From: Jonathan Parsons
Sent: 02 September 2011 12:02
To: 'lilleyarchitecture'
Subject: RE: 7 Webb Close, P/51/11
 Dear Mr Lilley

Thank you for your email dated 24th August. I have been on site now and remain unconvinced about this proposal.
 There are a number of issues.

Proposed Site Plan
1:500@A3

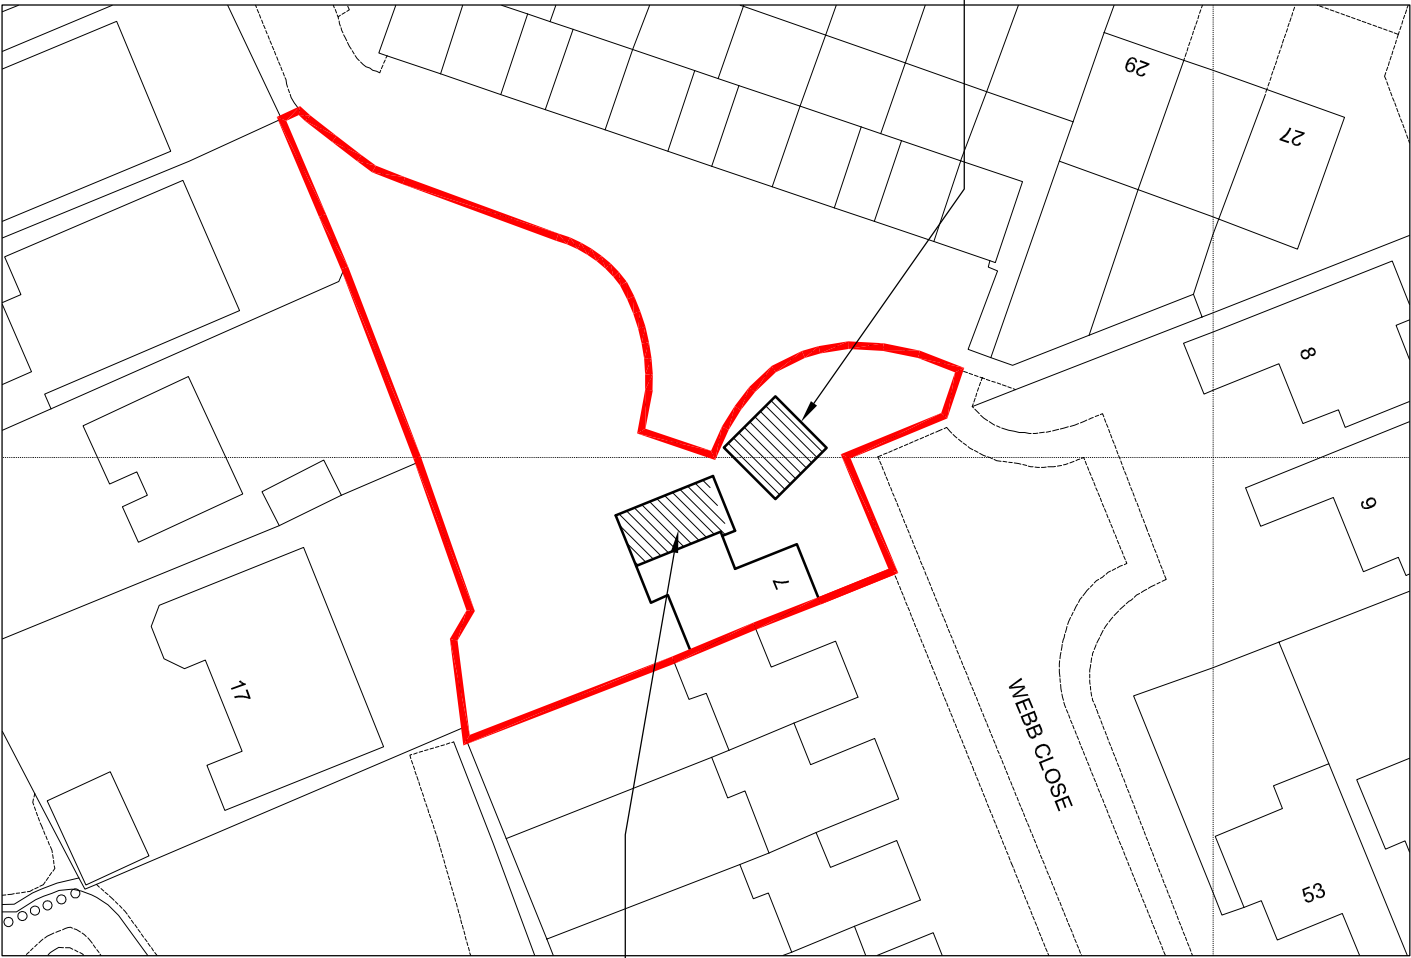
The rear balcony gives rise to overlooking to the dwelling at the rear which is at a lower level. The true relationship is not shown on site plan because the balcony footprint is not shown. However it is likely to be about 7 metres from the rear garden of 17 at its furthest extent. This is too close especially given the lower level of this property.

The group of trees within the amenity area at end of the Webb Close are attractive with a group public value and for this reason a Tree Preservation Order has been served on them to protect them. The double garage siting is likely to endanger them.

North (front)

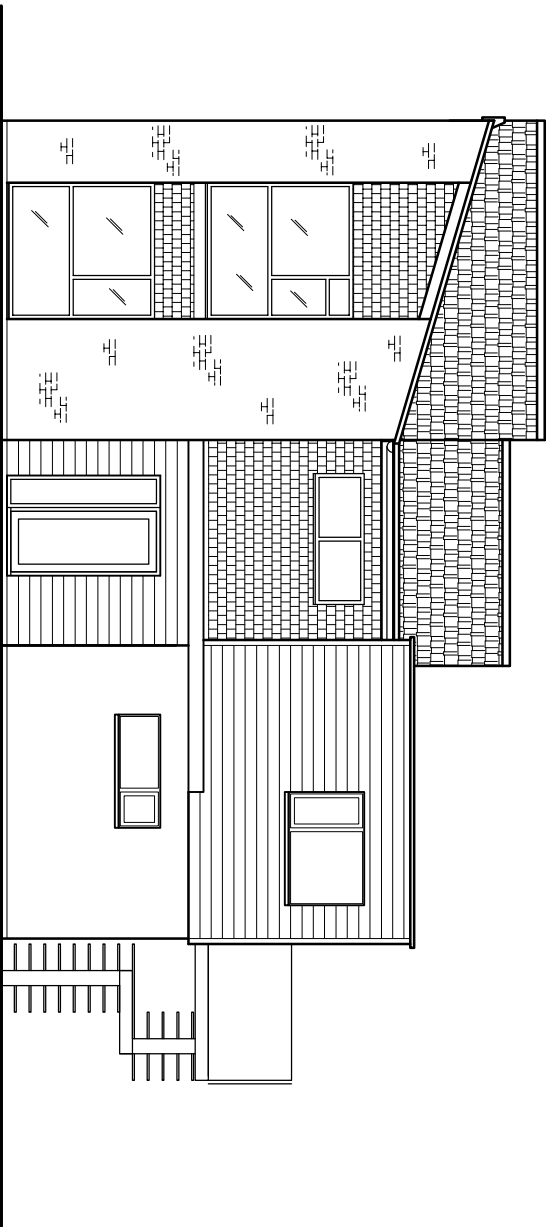
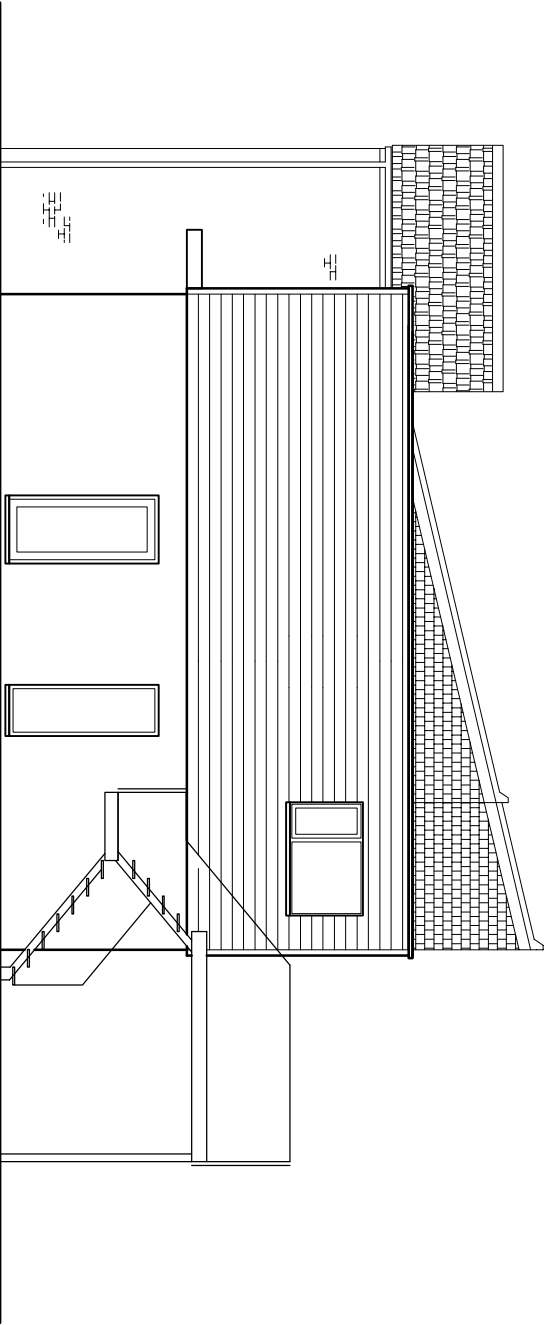
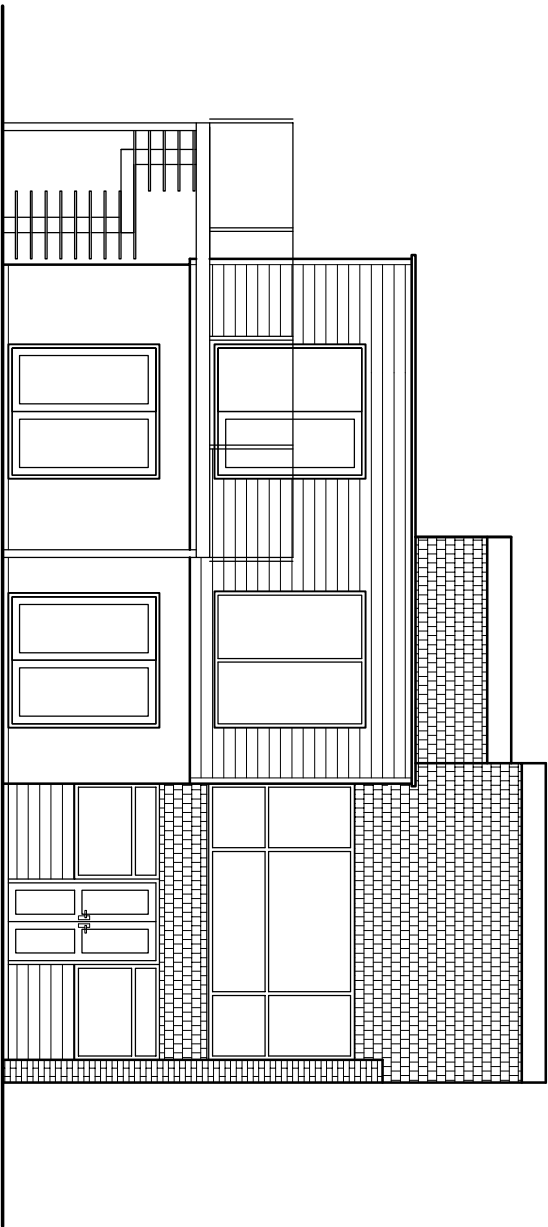
I note what you say about the reasons for the design. In particular that a mono pitch, saw tooth or dual pitch roof on the proposal may compete with the rhythm of the striking, contemporary arrangement of the existing terrace. However I remain of the view that the design approach should replicate the design as the existing design is so striking.
